Application number: 2024/90461	
What is the application for?:	Erection of detached dwelling with detached garage
Address of the site or building:	Land at Occupation Road, Off Birkby Road, Birkby, Huddersfield, HD2 2ES
Postcode:	HD3 4EY

Re land at Occupation Road, Off Birkby Road, Huddersfield

I am writing to put forward my concerns and object the planning application number 2024/90461.

Drawing Title
House Plans and Elevations

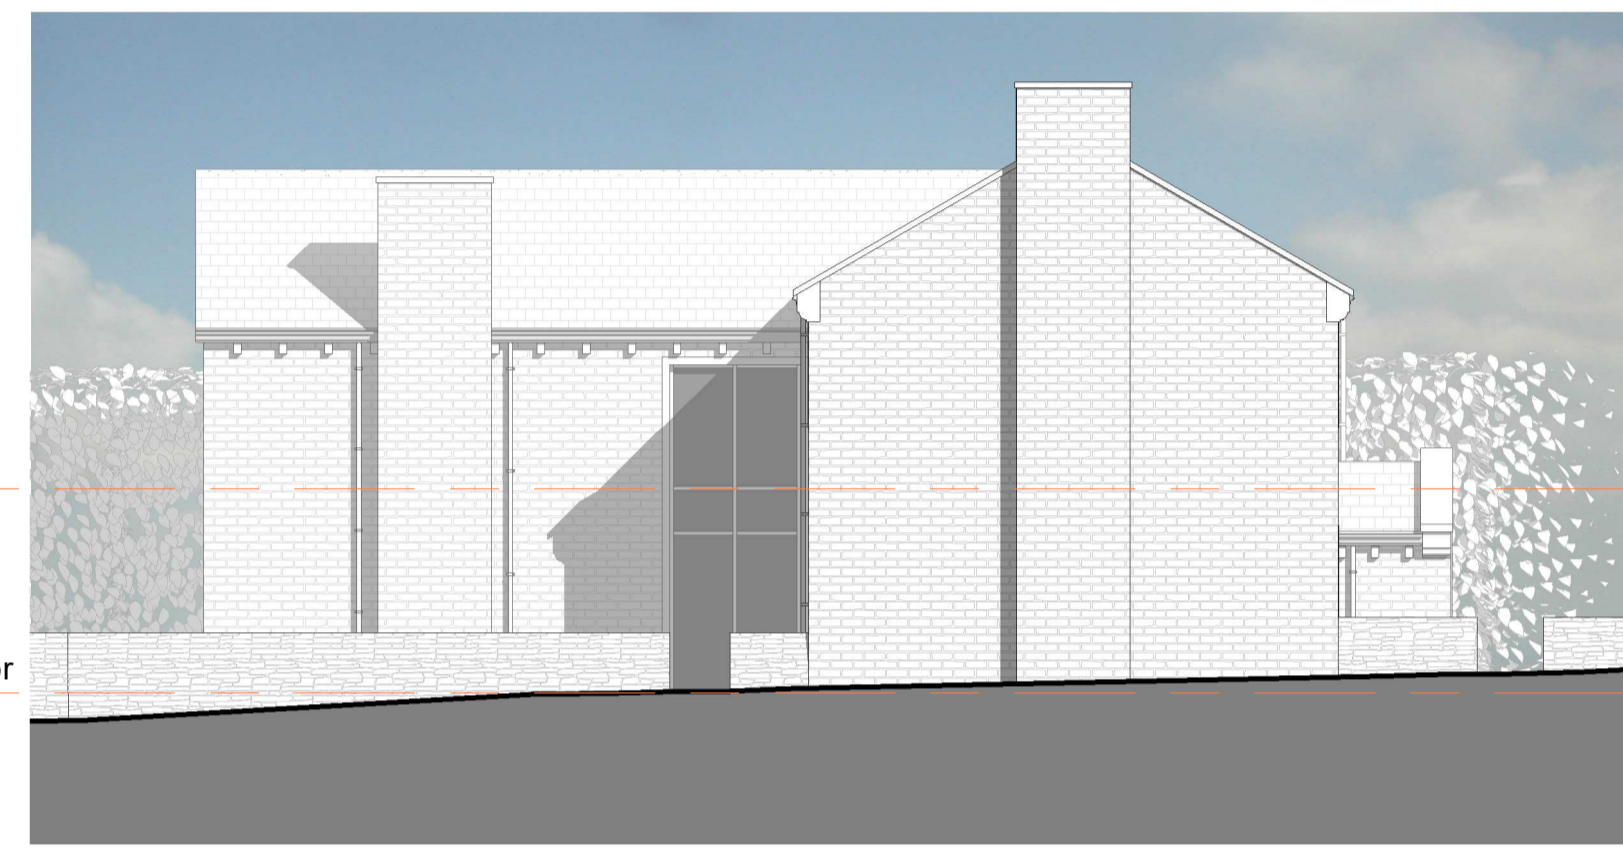
- The proposed dwelling overlooks our garden, kitchen, dining, and conservatory, compromising our privacy entirely.
- The rear master bedroom, entirely made of glass, will overlook our rear garden.
- The large driveway forecourt will overlook our conservatory, and car headlights will shine directly into our rear accommodation.
